From: Parish Clerk <deddingtonparishcouncil@googlemail.com>
Sent: 18 February 2021 10:05
To: Planning
Cc: 'Stella O'Neill'; David Rogers
Subject: Planning responses from Deddington Parish Council - February 2021

20/03360/REM Stone Pits, Hempton Road, Deddington reserved matters 18/02147/OUT consideration of appearance, landscape, layout and scale.

The Council asked for confirmation on how the following would be delivered:

LANDSCAPE MASTERPLAN
HARD AND SOFT LANDSCAPE

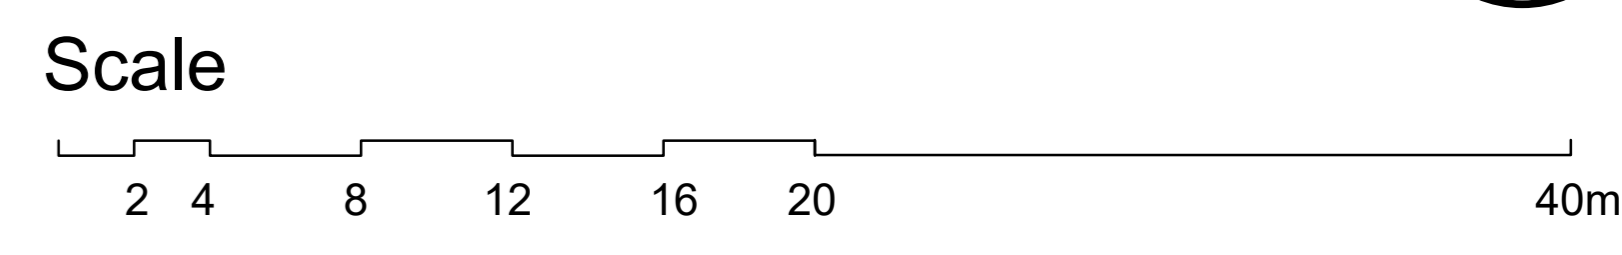
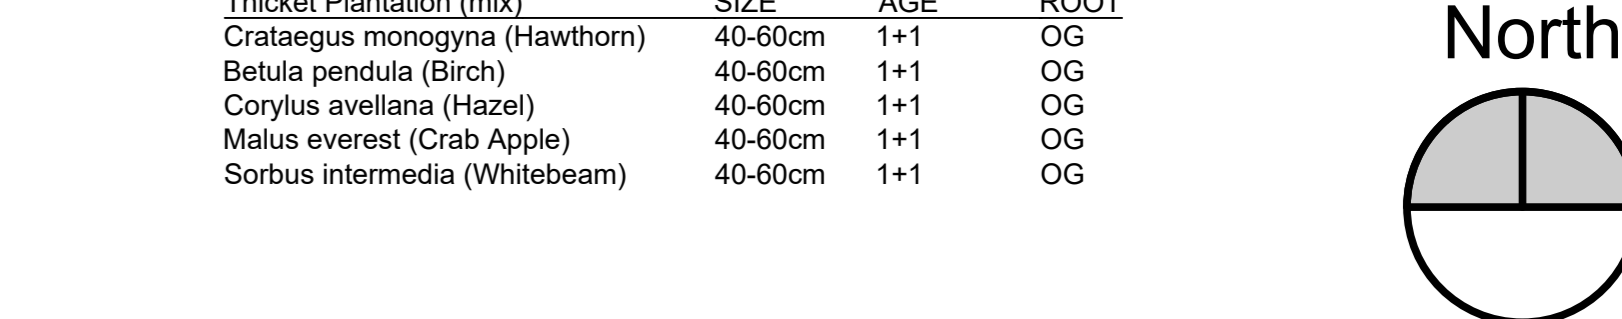
- **Landscaping to boundaries.** The PC request that there is a condition that the on-going costs and management of the landscape is clearly defined. Will there be an maintenance company responsible for this or an arrangement with OCC for the ongoing costs and management to be covered?
- **Link path to Wimborn Close.** The PC request confirmation of the financial contribution, in S106, for the construction and maintenance of the link path between the site and Wimborn Close.
- **Completion of S278.** To secure changes to highways alterations. In July 2020 the conditions on means of access and highways alterations were discharged, in accordance with a plan that shows the speed sign, and village welcome gates, with mini-protrusion to create Give Way chicane moved to the west. Has this S278 agreement been made to ensure these changes will go ahead?
- **S106 contribution confirmation.**
